Our Ref: R/2025/4/A
File No: 2025/229041
Your Ref: SSD 79316759

Advice on EIS – Concept Proposal for Mixed Use with Affordable Housing – 45-53 Macleay Street, Potts Point – SSD 79316759

Thank you for your correspondence dated 1 April 2025 inviting the City of Sydney Council (“the City”) to comment on the proposal at the abovementioned address. The application proposes a concept envelope for a building approximately 50.05m in height (13-storeys) comprising a mix of market and affordable housing and commercial uses.

Drawing Name
FLOOR PLAN B3-B2

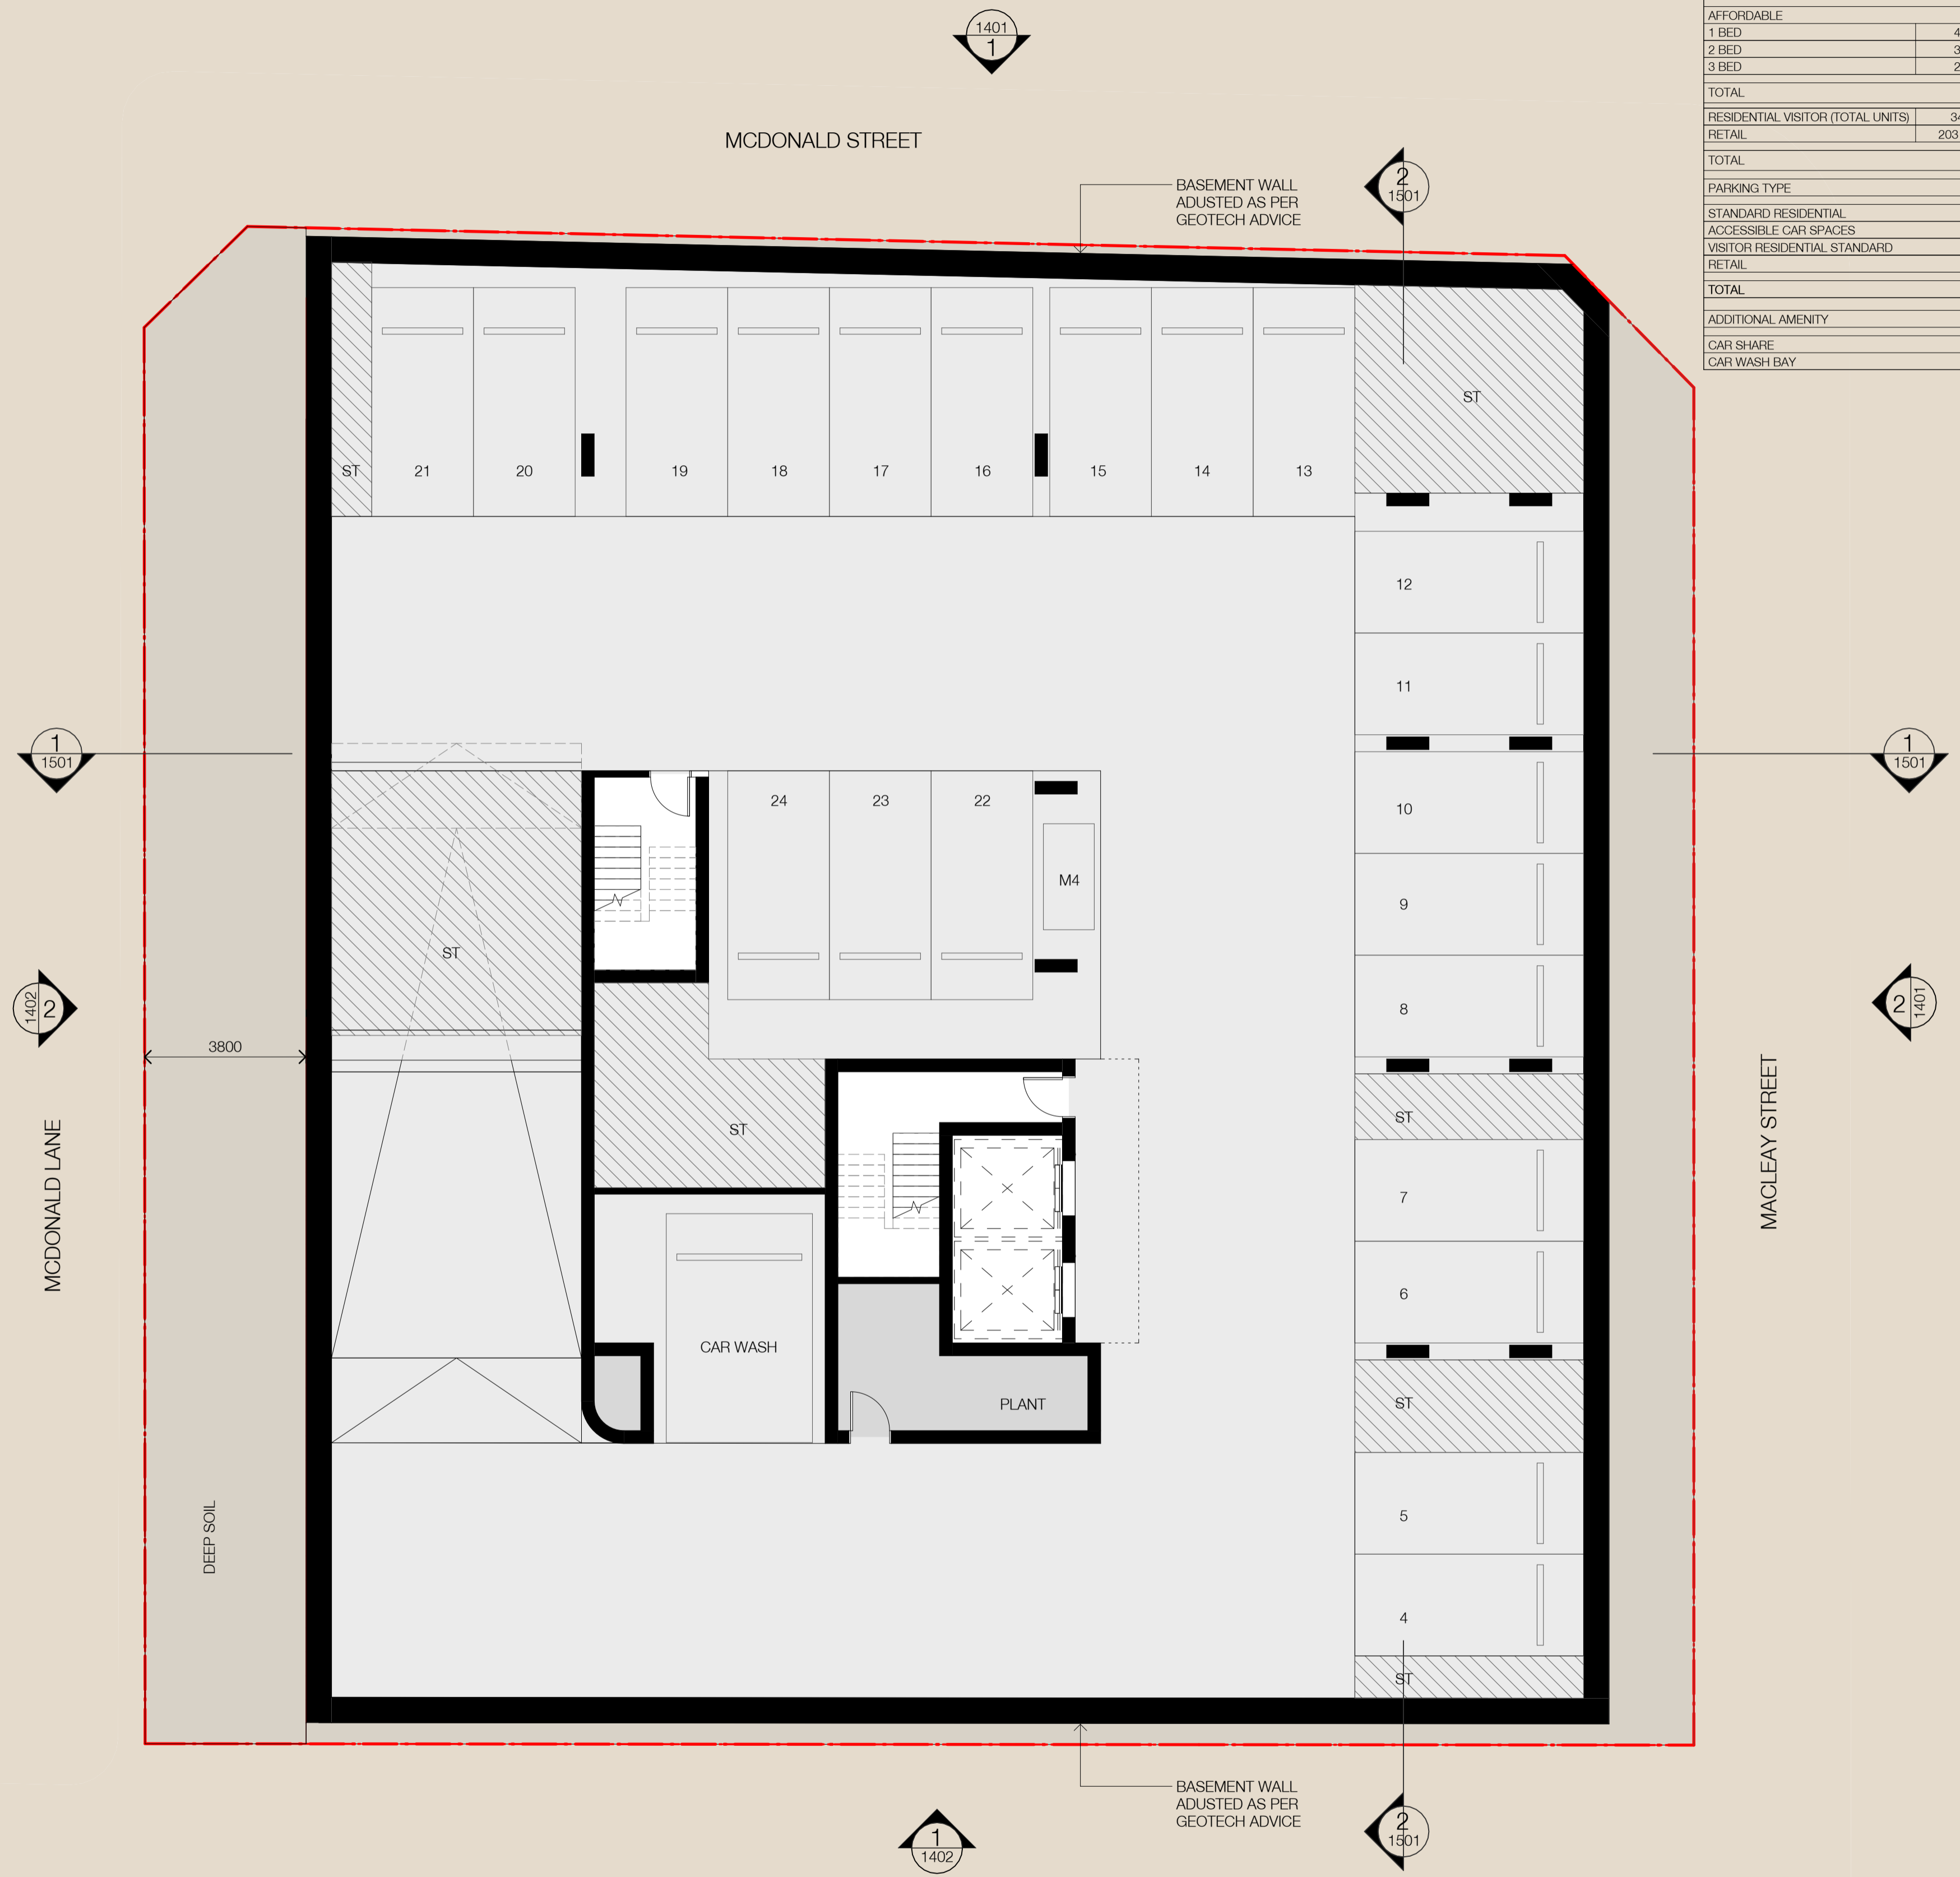
Envelope plans do not incorporate an adequate basement setback file piling/structure and drainage to ensure any future basement will be located outside the zone of influence of the footings of adjoining heritage listed items to the south.

Drawing Name
FLOOR PLAN GROUND

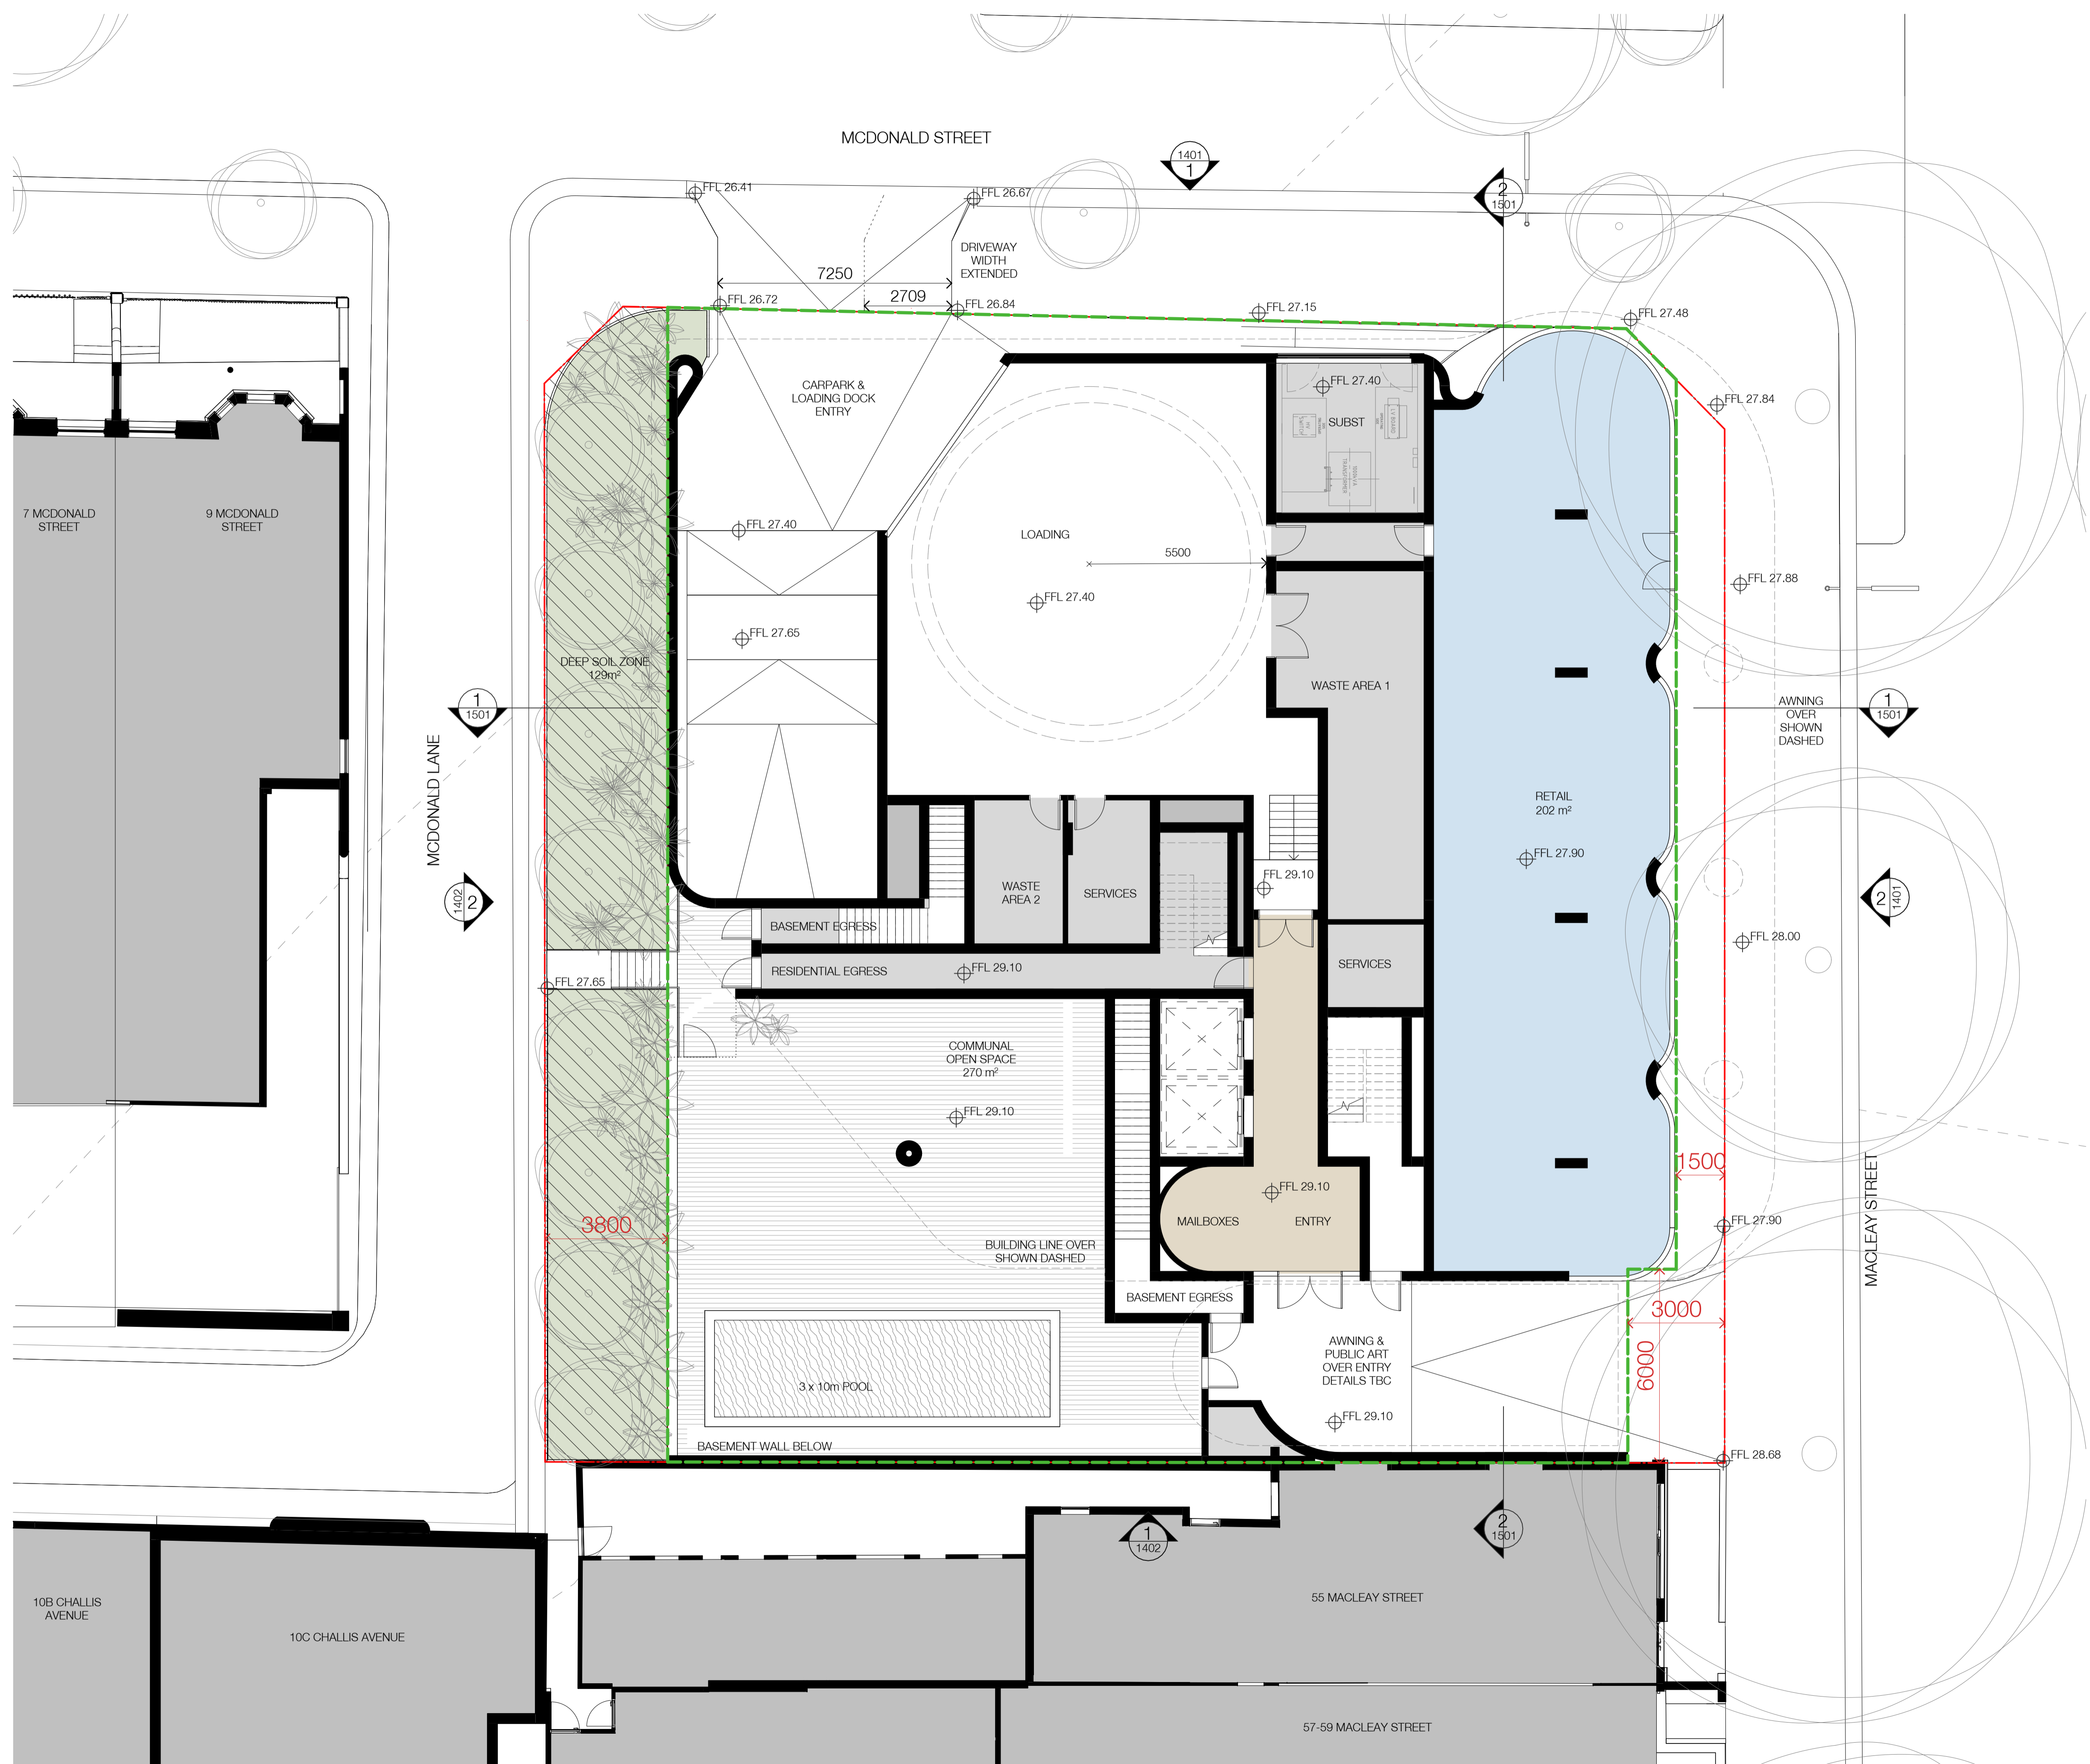
The proposed envelope has an inadequate setback to Macleay Street. The basement and podium (GF-L2) must be set back a minimum of 2m to avoid impact on the existing street trees both for long term clearance to the future building and to allow room for construction hoarding without the need for excessive pruning.

Similarly, no awning should be provided on the Macleay Street frontage where it will create a long-term impact on street trees.

- Whilst noted on the envelope plans (Ground Floor & Below), the drawing identified two separate entries on McDonald Lane. Two entries are not supported, and a single consolidated vehicular entry must be considered in any future design and must be designed to DCP width requirements.
